Fire Marshal Division

**Re: CCCC Auto Restoration
220 Olive Farm Drive
Sanford, NC 27332**

Application Number FMFW1808-0001

FIRE SUPPRESSION SYSTEM
PAINT MIXING ROOM

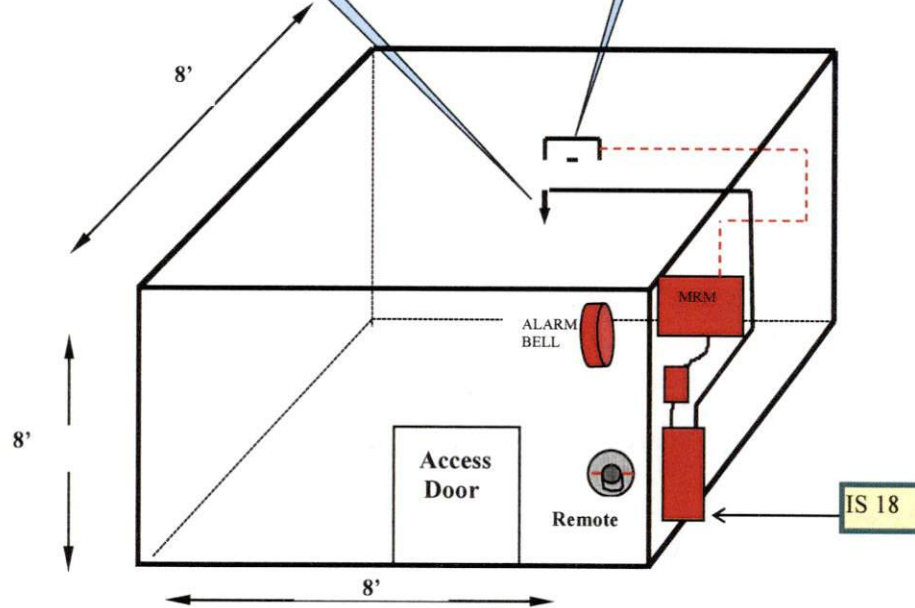
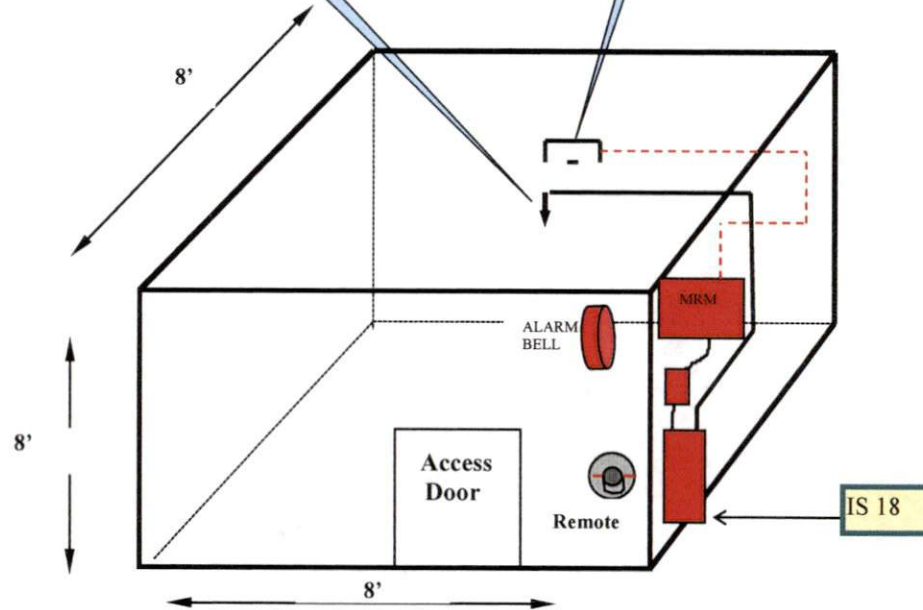
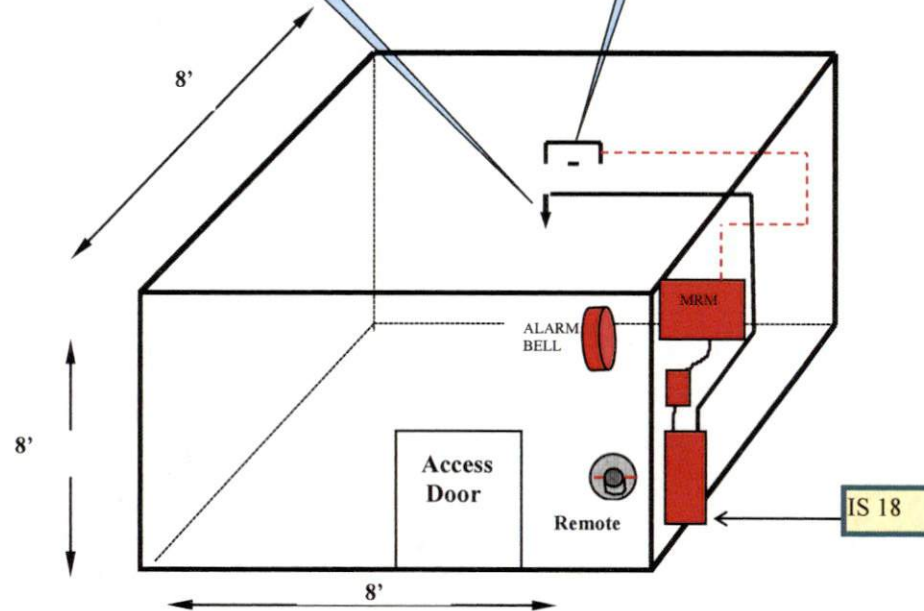
- **904.6 Dry-chemical systems.**
 - Dry-chemical extinguishing systems shall be installed, maintained, periodically inspected and tested in accordance with the North Carolina Fire Prevention Code, NFPA 17 and their listing.
- **1504.7.1 Ventilation Interlocks**
 - With a total flooding system, the ventilation system for the paint booth is required to shut down before the system operates.
 - Spaying operations **CANNOT** be conducted without the operation of the ventilation system. An interlock must be provided between the ventilation system and spraying operation.
- **Fire Extinguisher**
 - Fire extinguishers of a rating no less than 4A:40 BC shall be within a 30 ft. travel distance from the paint booths.
- **904.4.1 Inspection.**

- Prior to conducting final acceptance tests, the following items shall be inspected:
- Hazard specification for consistency with design hazard.
- Type, location and spacing of automatic- and manual- initiating devices.
 - Size, placement and position of nozzles or discharge orifices.
 - Location and identification of audible and visible alarm devices.
 - Identification of devices with proper designations.
 - Operating instructions.
